CITY OF ALBUQUERQUE

Re: Fiesta Subaru 7100 Lomas Blvd. NE
4400 Cutler Ave. NE
Traffic Circulation Layout
Architect's Stamp 4-28-22 (K19-D108A)

Traffic Control Layout Comment Response

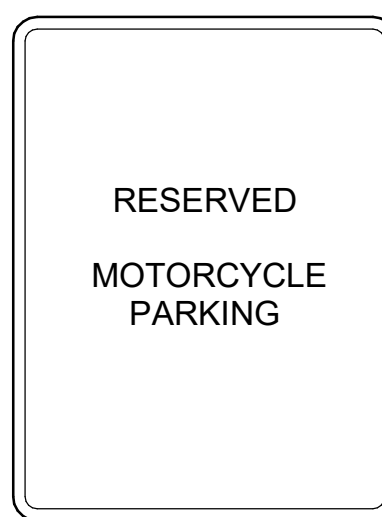
- PAINTED DIRECTIONAL ARROW- See Added Detail A7/AS501
 - INSTALL VAN ACCESSIBLE PARKING SIGN & PAVEMENT MARKING. SEE DETAILS A1/AS501 & J10/AS102.
 - INSTALL CONCRETE WHEEL STOP PER DETAIL F7/AS501.

A10 DOUBLE PIPE GATE-ELEVATION

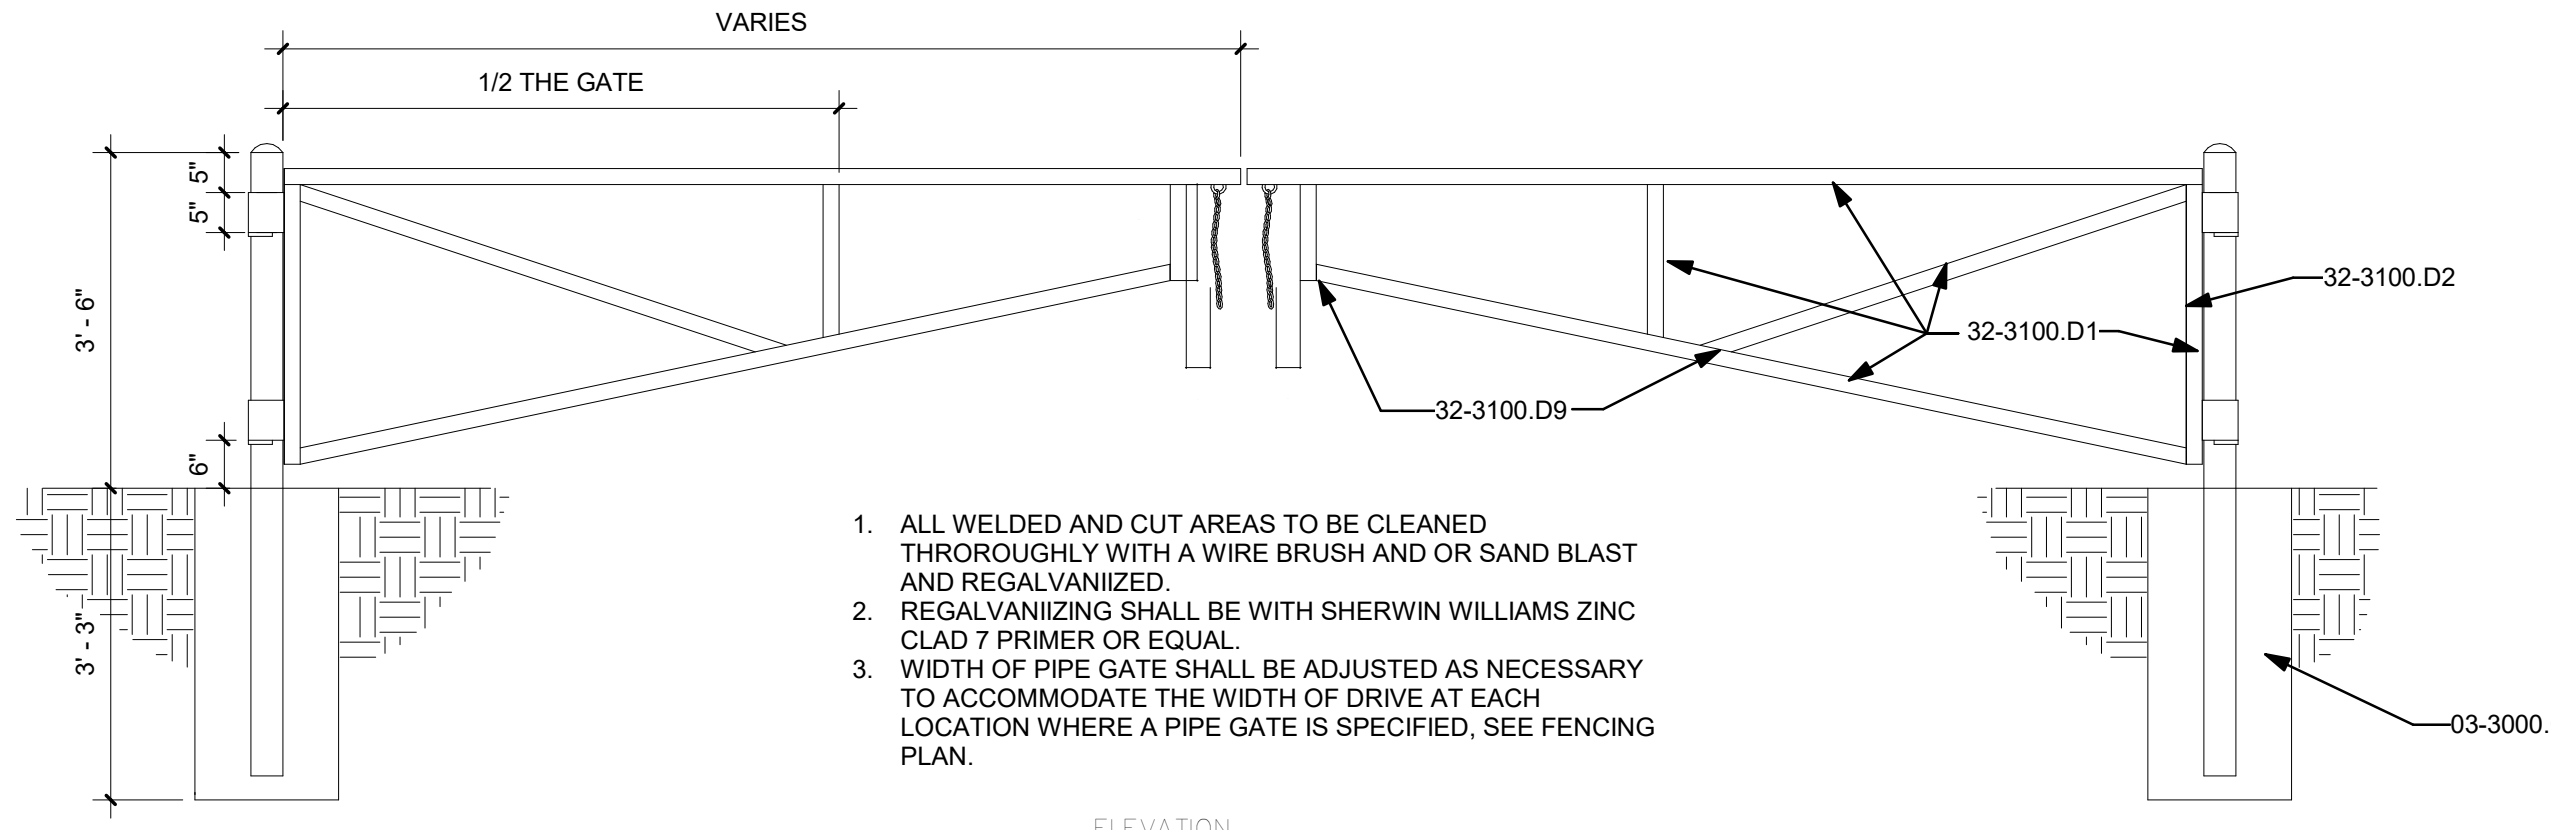
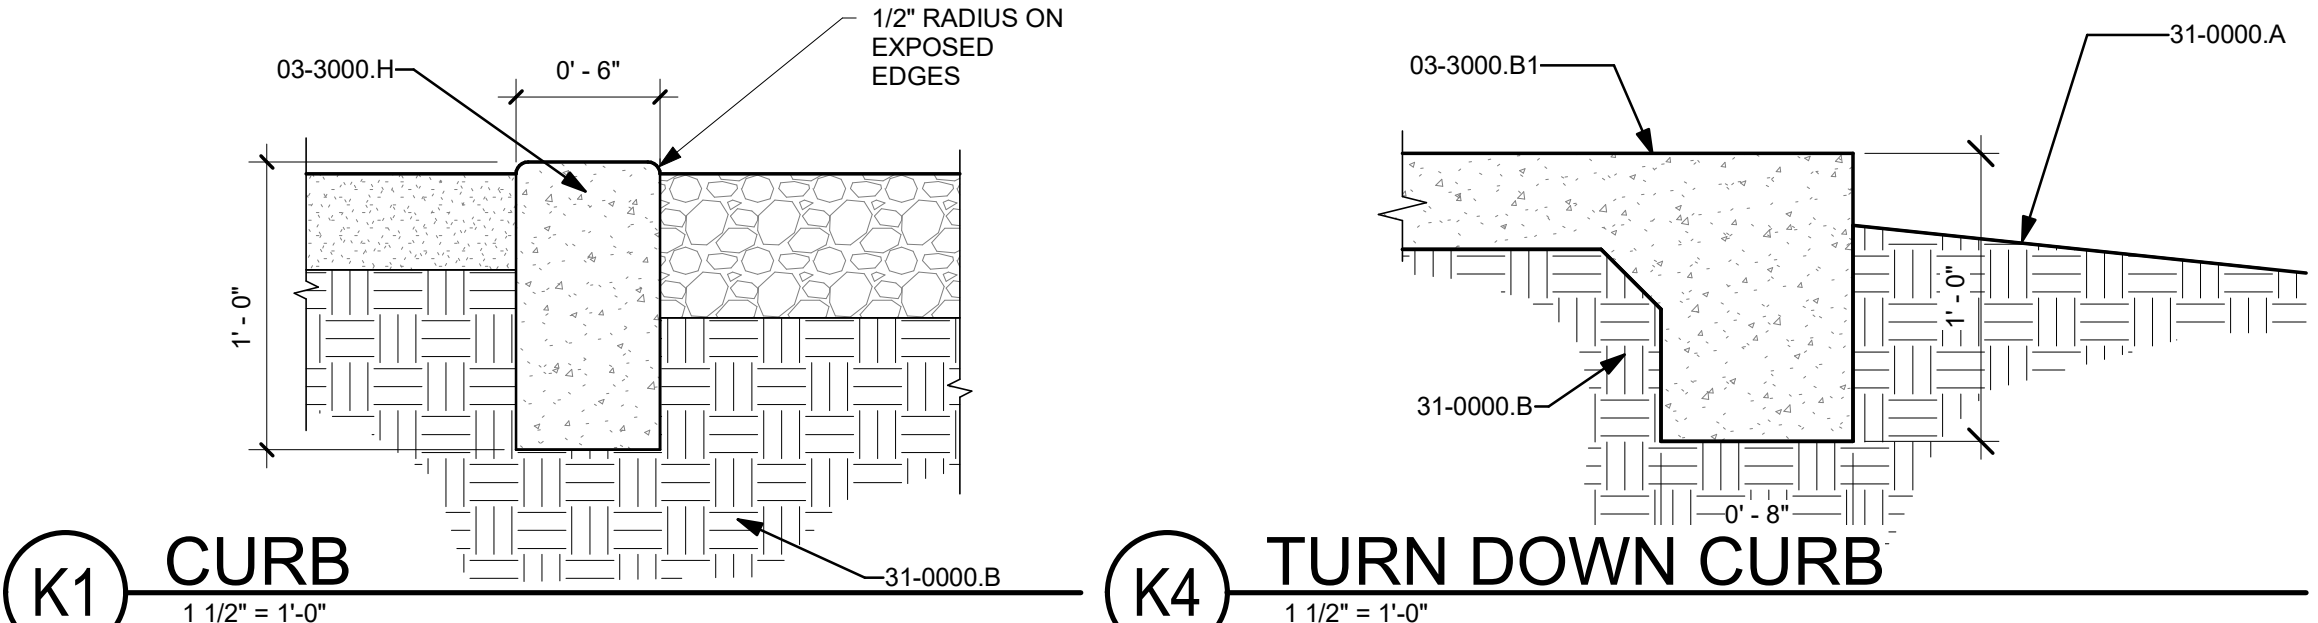
9. Louisiana's, Lomas's and Chama's main access with proposed gates will need a setback of 20 feet to provide turnout.
 - Revised gate design attached.
10. A sidewalk easement will be needed at the corner of Louisiana/Lomas to encompass the full size of new ramp.

A1 SITE PLAN

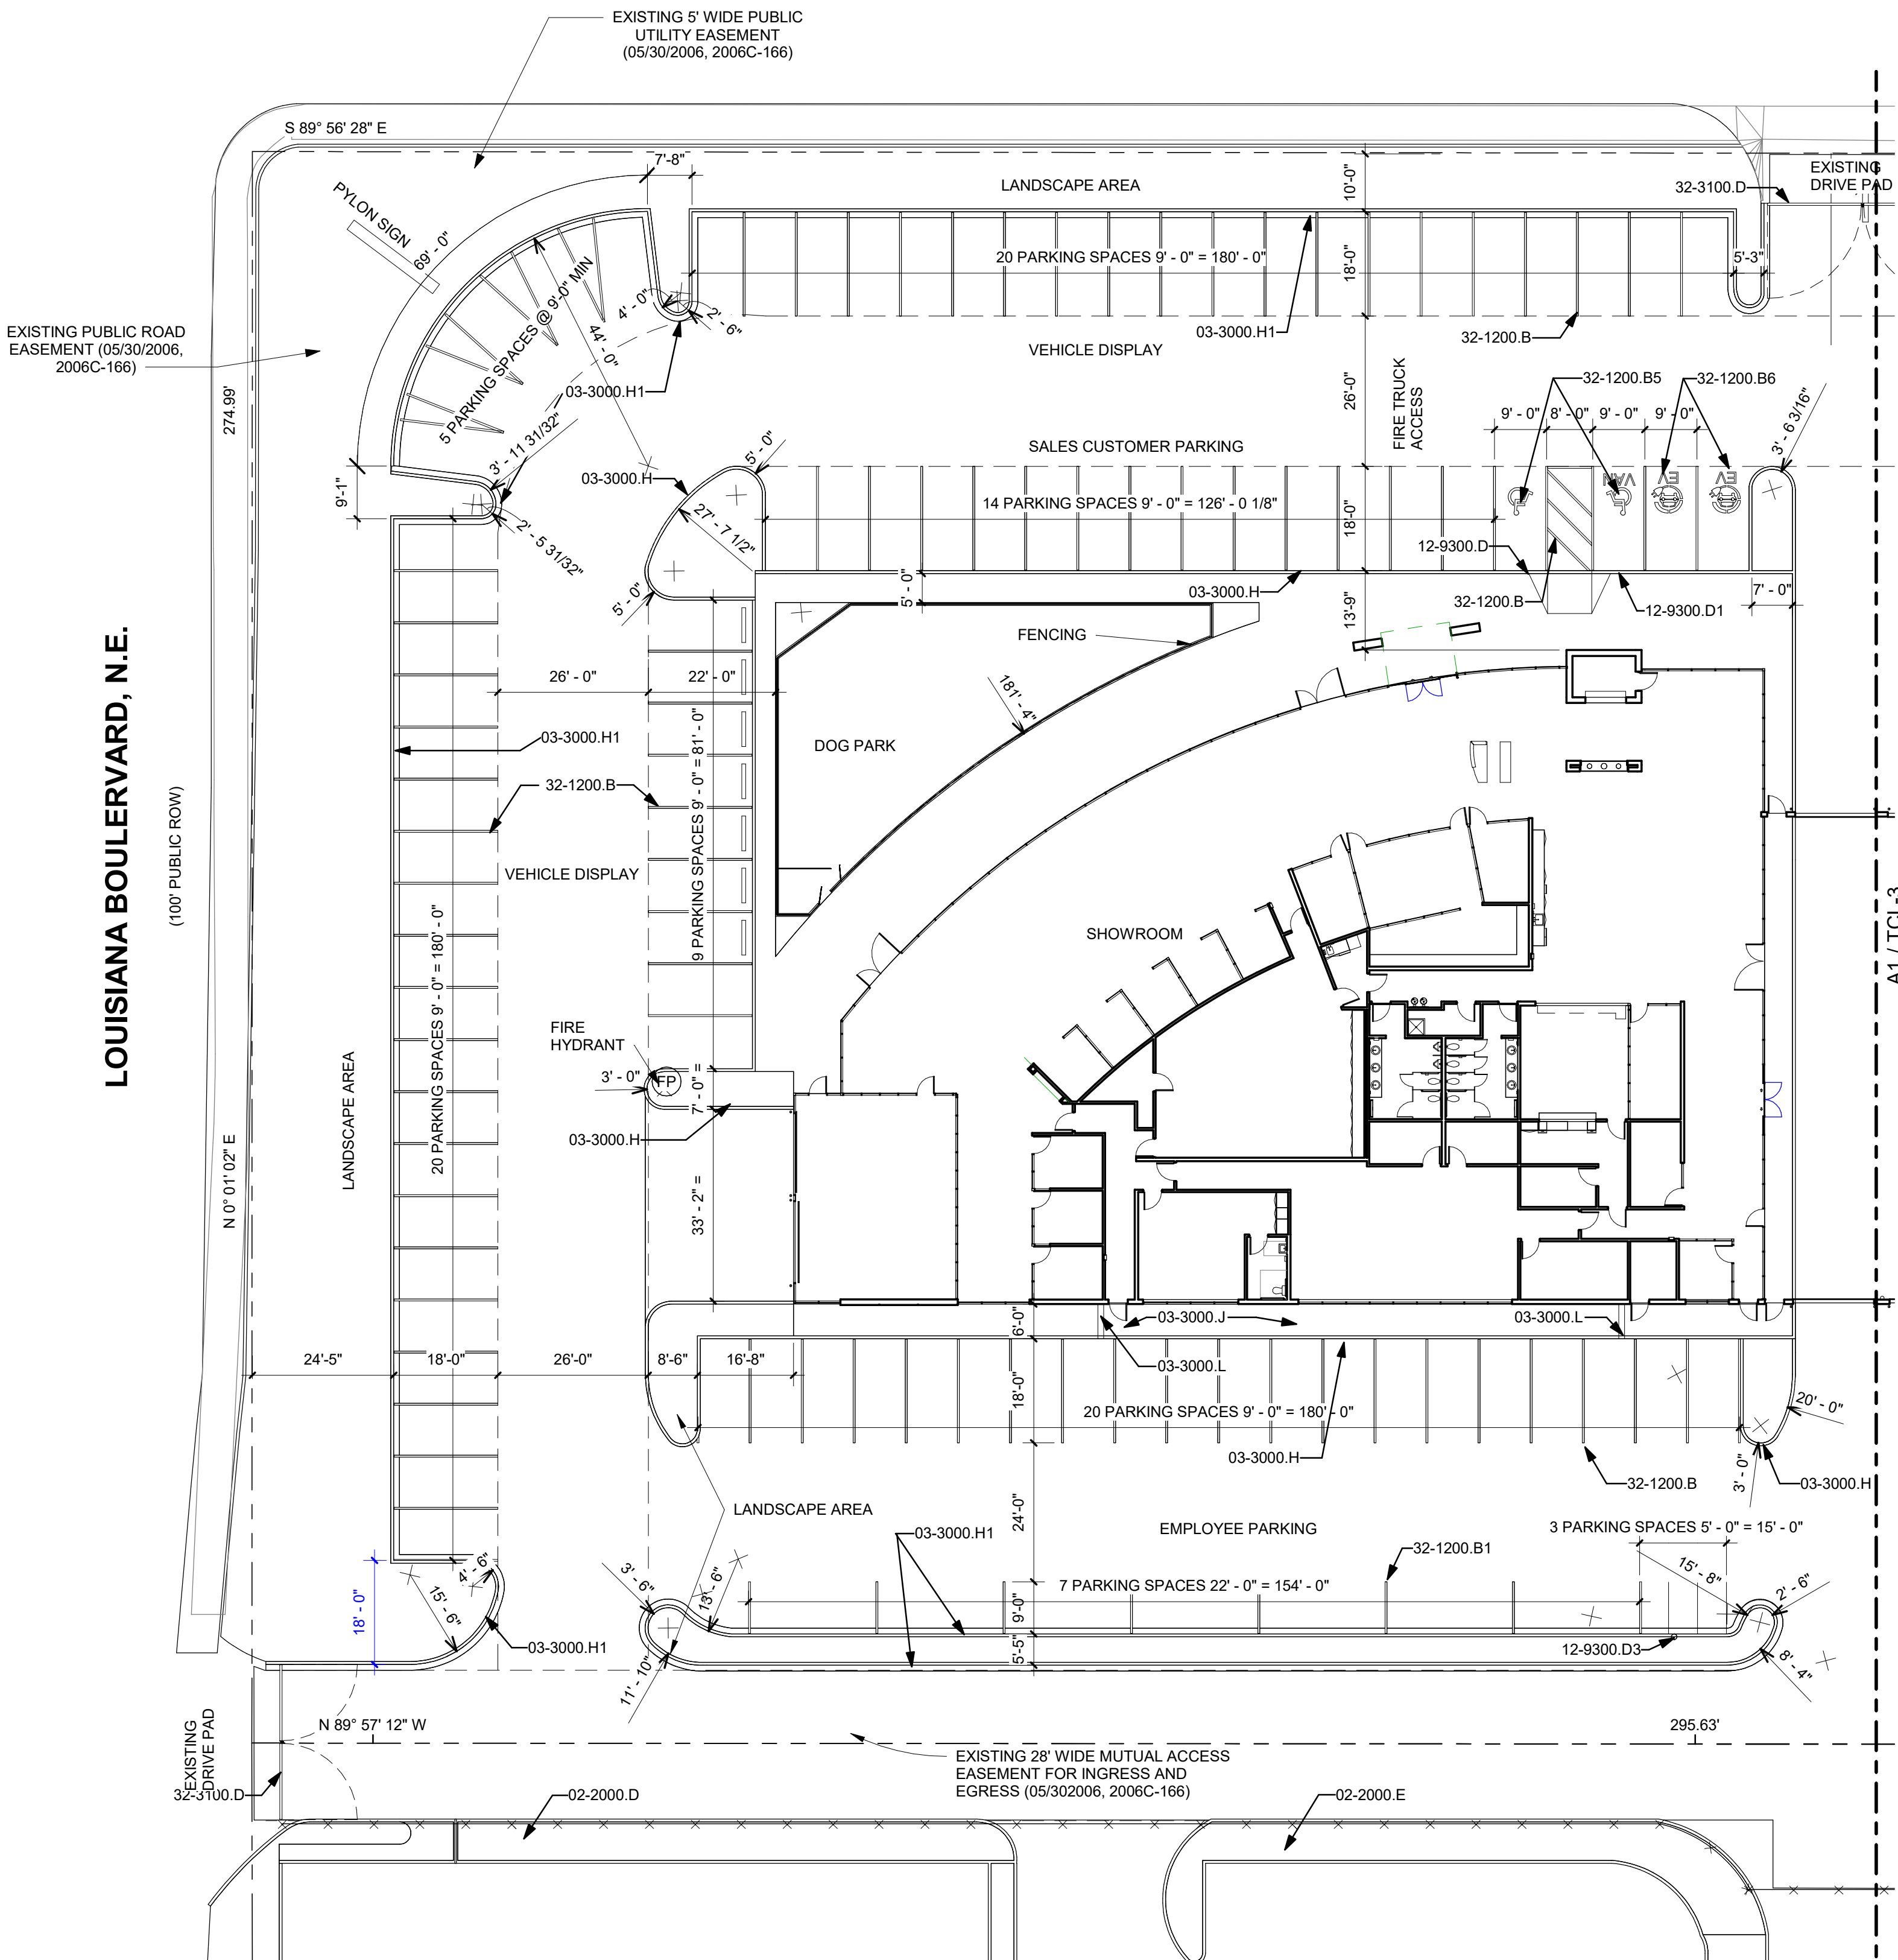
1. Listed are the number of Bicycle parking spaces required by the IDO Coordinate/discuss with Zoning. See revised bicycle Parking count
2. Louisiana/Lomas:
The Minimum Throat depth off an Arterial needs to be comply, please review DPM Design Criteria Table 7.4.81 Minimum Throat Length.

- Per Meeting March 14, 2022 - Current layout will be approved pending adjustment of gates and ADA drives
3. An ADA ramp will need to be provided at the corner of Louisiana/Lomas. The existing ramp doesn't provide a minimum pathway width of 4ft to service ADA prior to ramp landing.

- Sidewalks at corner of Lomas and Louisiana have been changed to have a 48" clearance from the poer pole and the traffic light post
4. All existing drive pads off Louisiana and Lomas are not ADA accessible. So the will need to be ADA accessible and the design will need to be Curb Return since both roadways are classified as Arterial.

- Drives need to have accessible path. City prefers curb returns (COA STD DWG 2426)
5. Please label the name of side street on the eastern property. Chama?

- Chama Street label added
6. Identify the right of way width, medians, curb cuts, and street widths on Chamas St. NE
 - See attached Chama ROW PDF
7. Provide details for all proposed pavement markings –

8. Chama's existing drive pads aren't ADA accessible and will need to be addressed.
 - Drives need to have accessible path. City prefers curb returns (COA STD DWG 2426)

19. All internal radii's will need to be 15 feet.

29. Shared Site access: driveways that straddle property lines, or are entirely on one property but are to be used by another property, shall have an access easement. Please provide a copy of the Access Easement for all properties abutting general lot and entrance access off Louisiana.

- See Attached plat showing this easement
30. Unused curb cuts must be replaced with sidewalk and curb & gutter. A build note must be provided referring to the appropriate City Standard drawing (2430 & 2415A). Two have been identified but not addressed off Louisiana.
